REQUEST

Current Zoning: R-3 (residential)
Proposed Zoning: UR-2 (CD) (urban residential, conditional)

Approximately 2.96 acres located at the 2400 block of Mecklenburg Avenue, just east of its intersection with Matheson Avenue near the Charlotte Country Club.

The petition proposes to rezone and redevelop a residential lot currently occupied by a historic home (Shaw House) to create a cottage community of 11 single family detached and duplex housing units while preserving the historic residential structure. The proposal represents an overall density of 3.71 dwelling units per acre (DUA).

TECHNICAL DATA SHEET

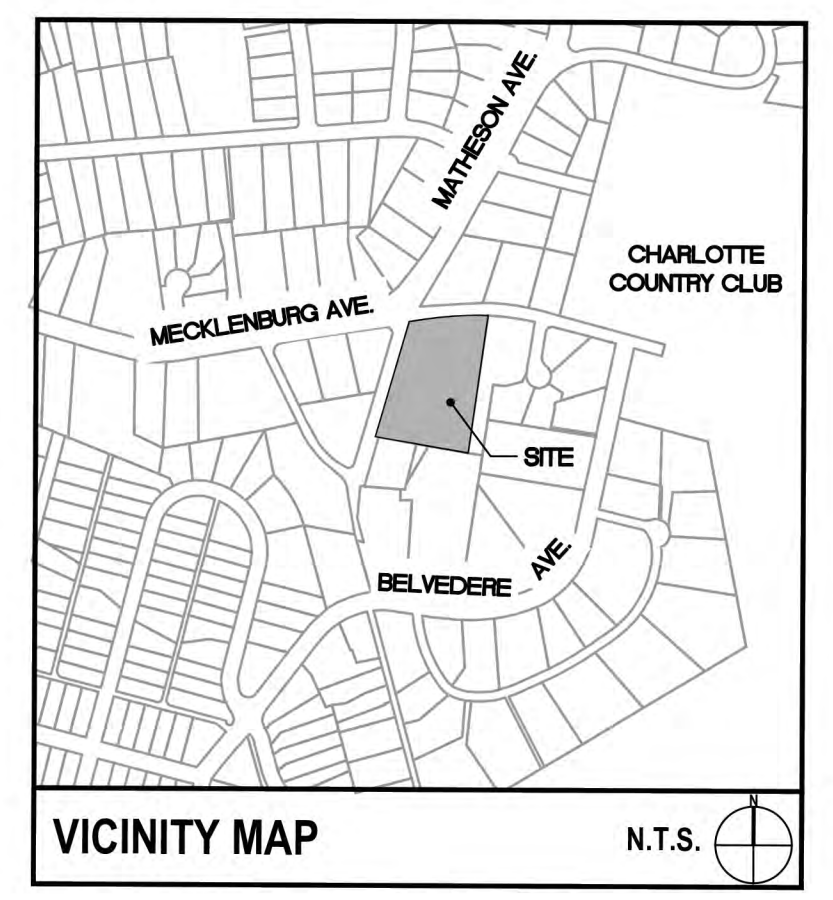
2. Revise numbering for Section E.
3. On Page 2, revise proposed zoning to UR-2 (CD).
4. Illustrate side and rear yards on site plan.

RZ-4

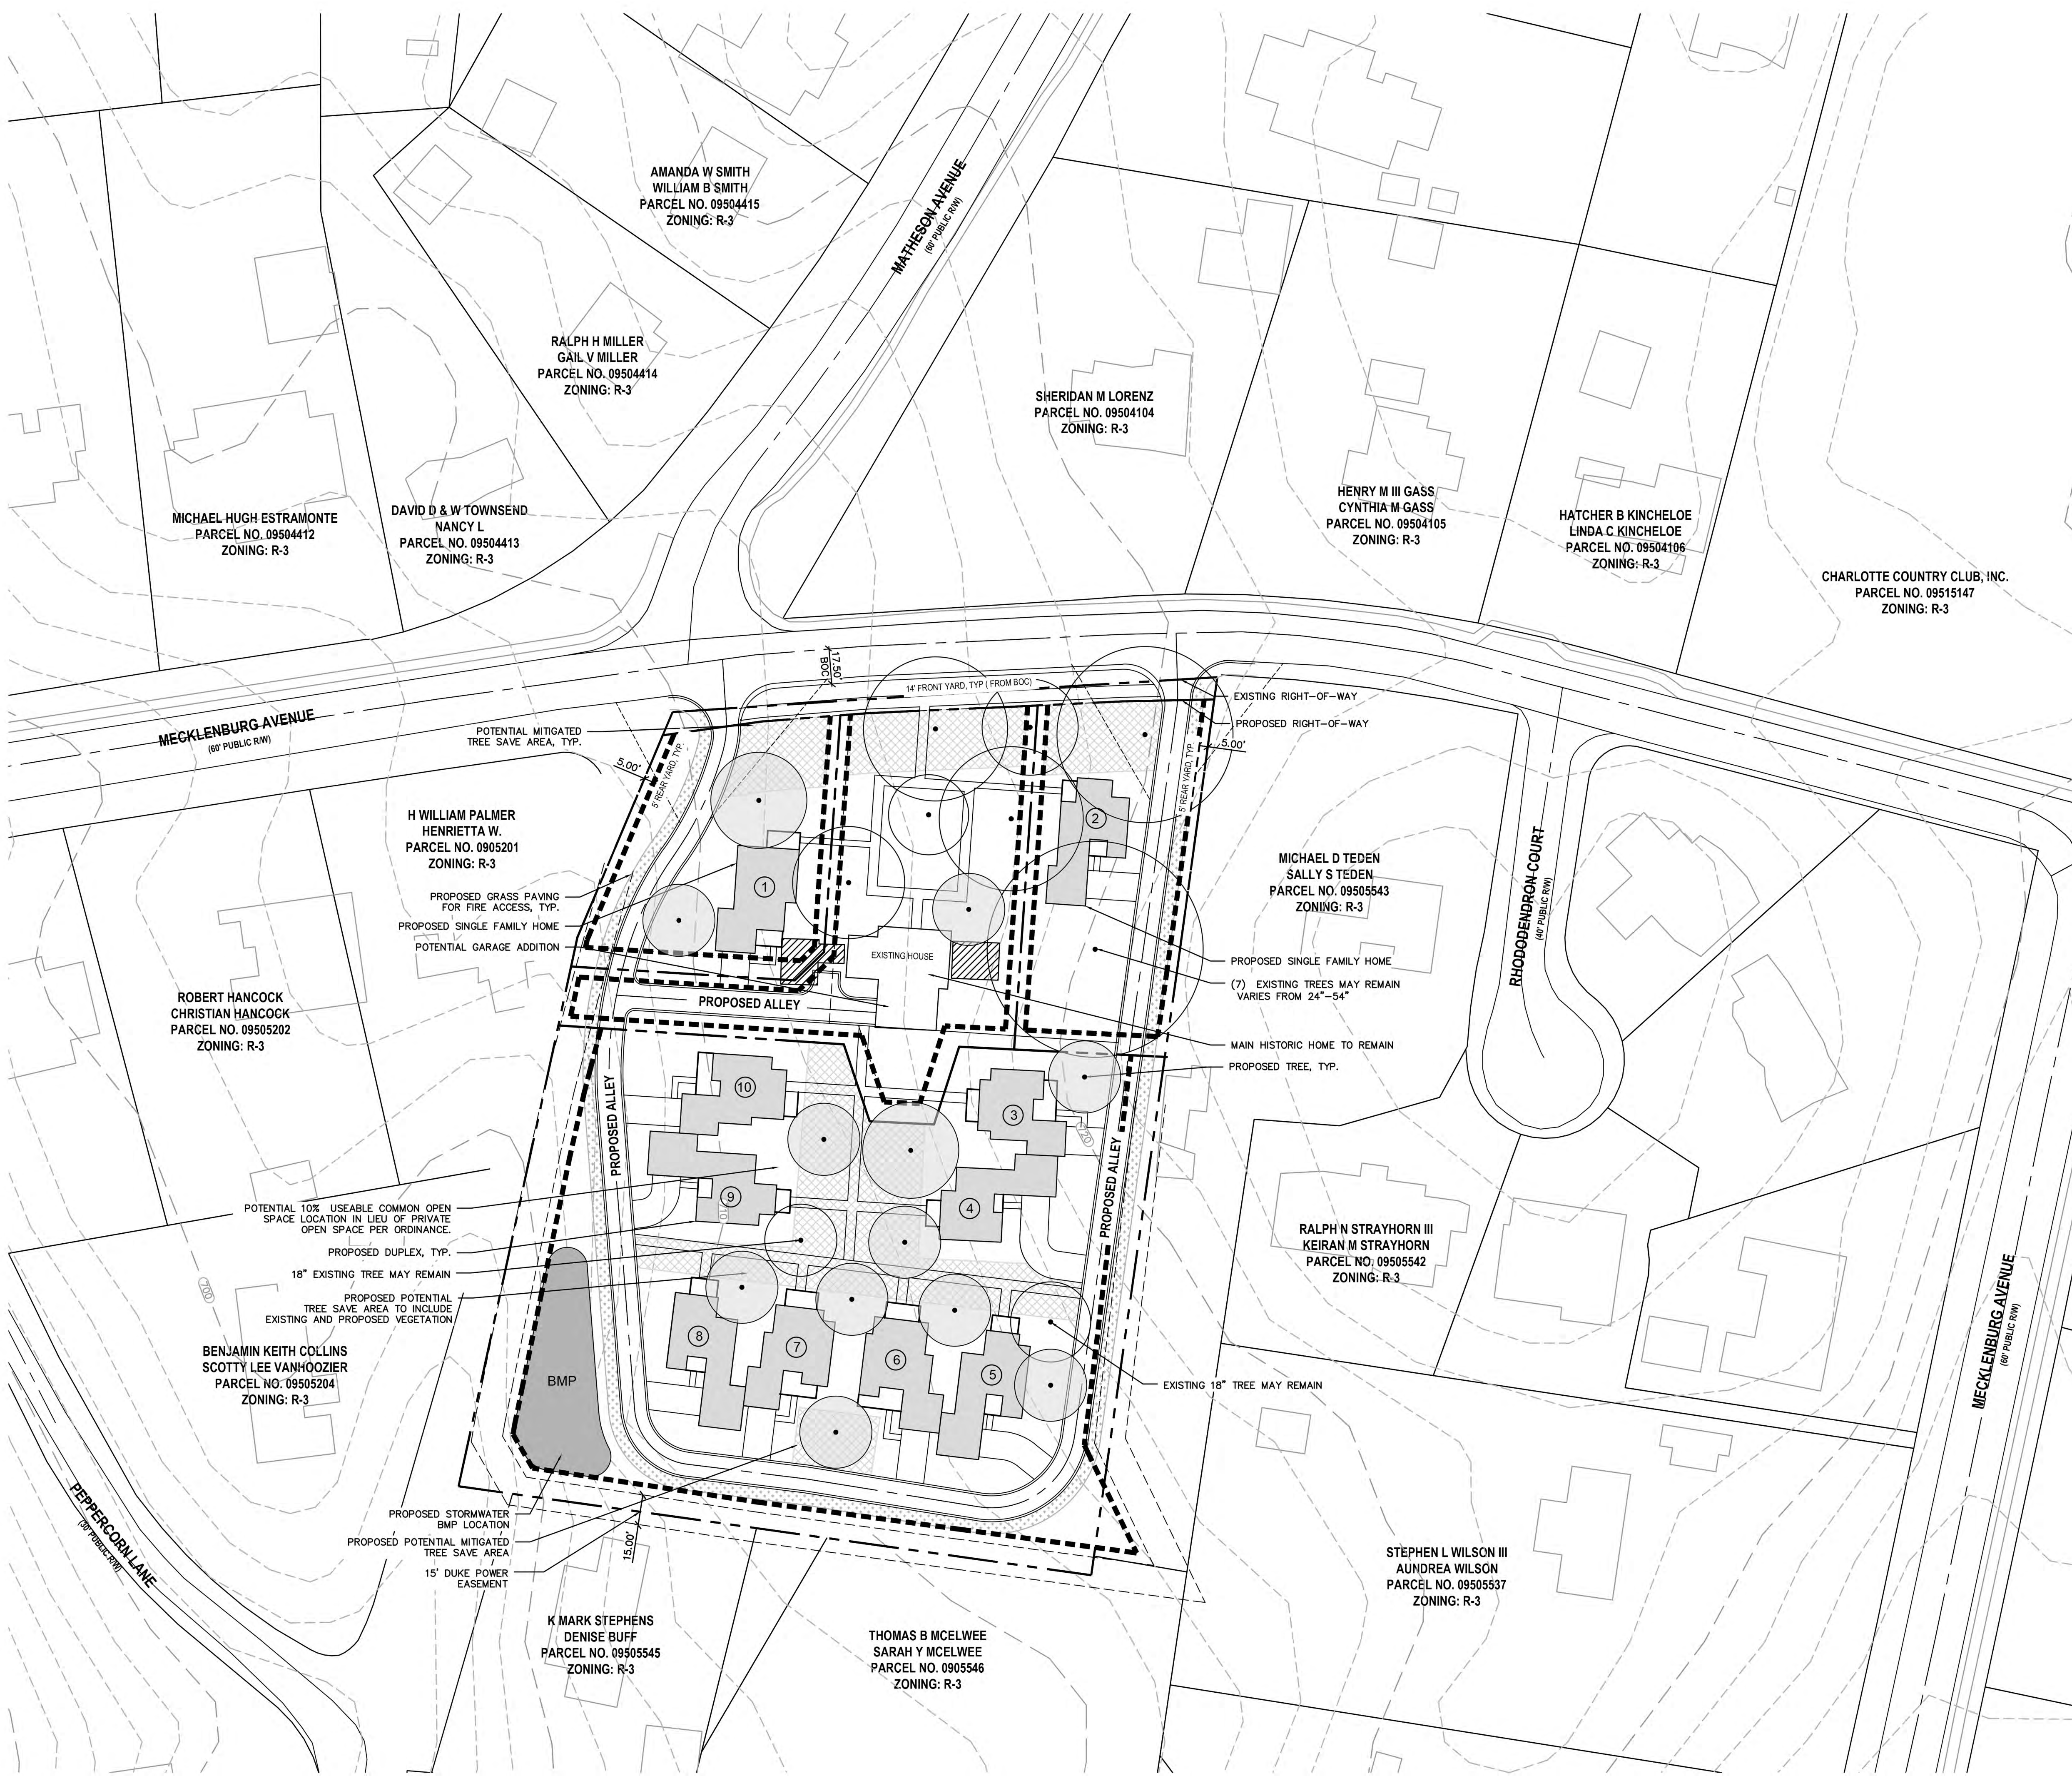
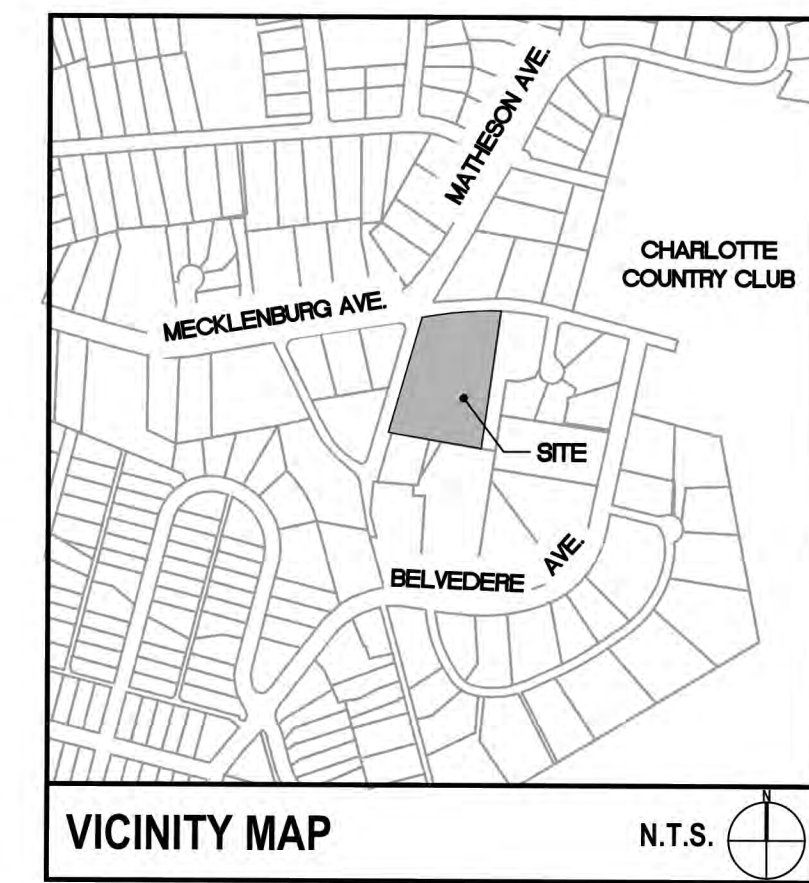
1. Remove notes 4 and 5 under Environmental Features section and replace with the following: For adjoining parcels receiving storm water discharge the petitioner shall analyze the adequacy of the existing storm water conveyance on the adjoining parcels to the downstream channel (identified by the SWIM/PCSO buffer west of Peppercorn Ln). If the existing storm water conveyance on the adjoining parcels is found to be inadequate, the Petitioner shall make a good faith effort with the property owner(s) to improve the storm water conveyance or mitigate the storm water discharge onto the adjoining parcels.
